**PLAN REVIEW SHEET**

**Petition #:** RZP 2022-121

**Address:** 9621 Elm Lane

**Request:** UR-2 (CD)

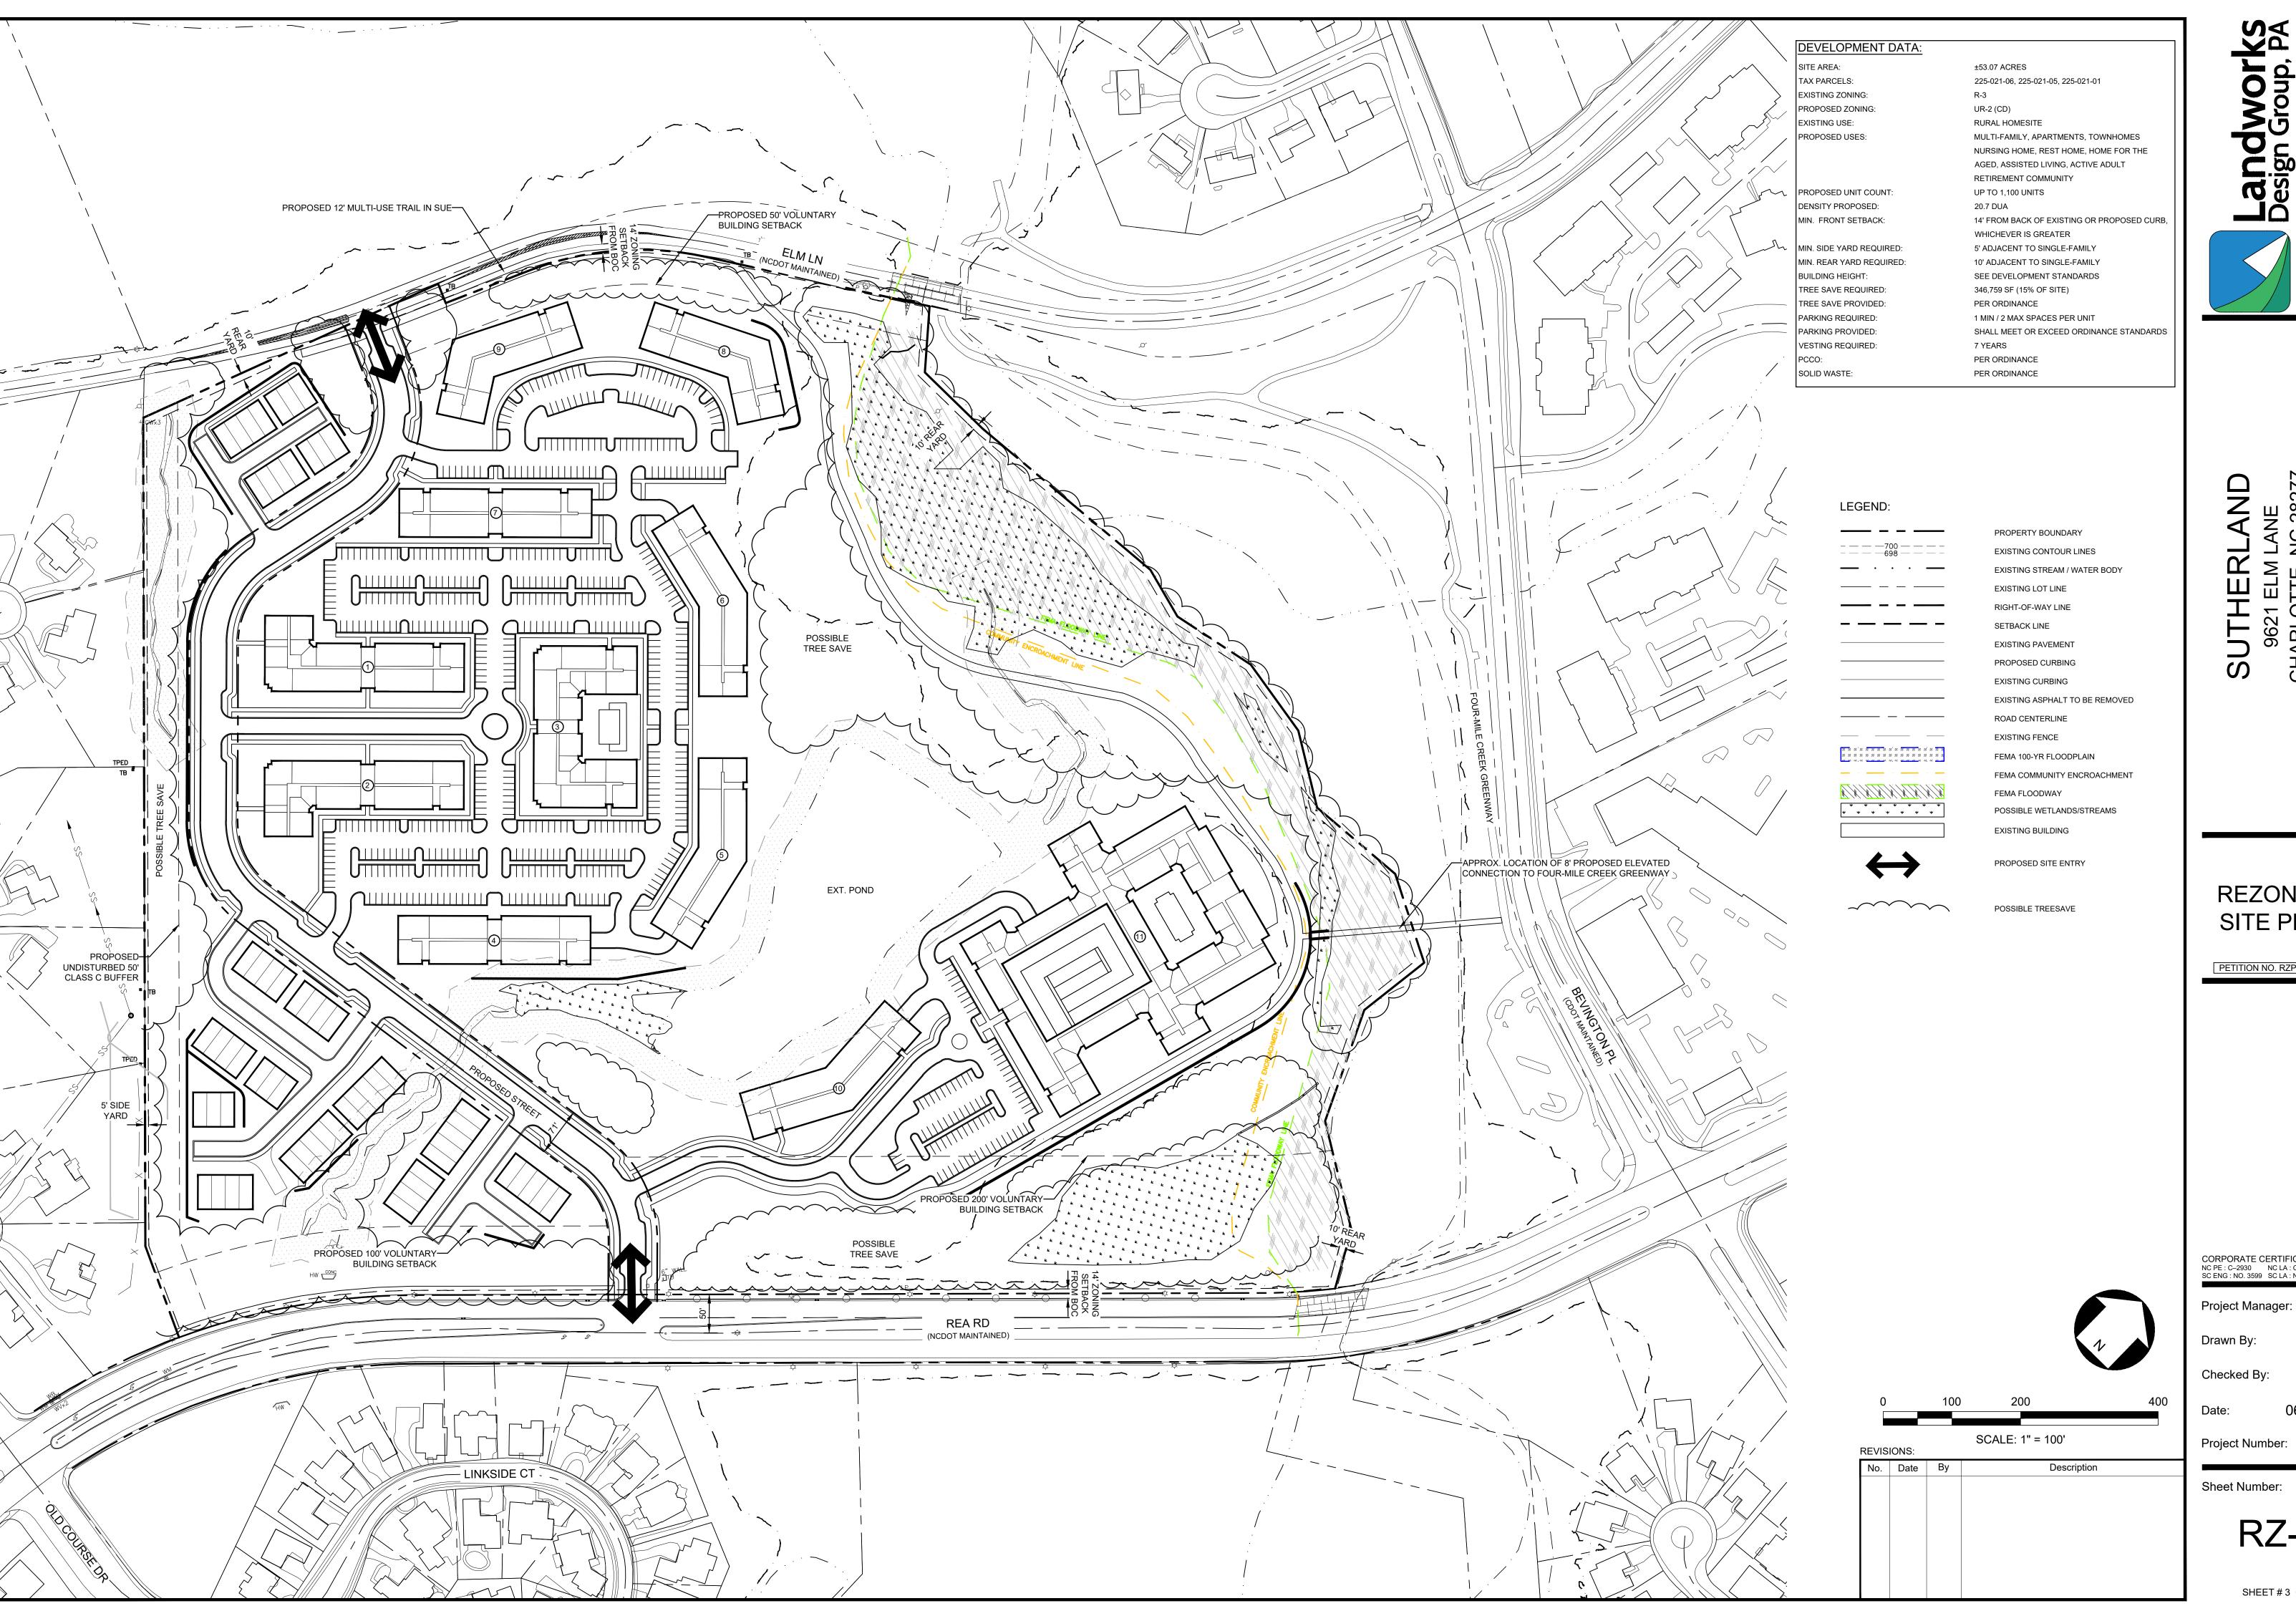
The site is located along CATS express bus route #62x on Rea Rd. Relocate the bus stop on Rea Rd. at Bevington Place to be a far-side stop using bus pad detail 60.01A. CATS also requests a sidewalk connection to the Bevington Place intersection with a curb ramp per ADA requirements. An alternative location would be far-side of proposed public street between the curb and multi-use path. CATS preference is to keep as close to Bevington Place to maintain integrity of bus stop pair. The final location will be coordinated with the developer during the Land Development plan review process.
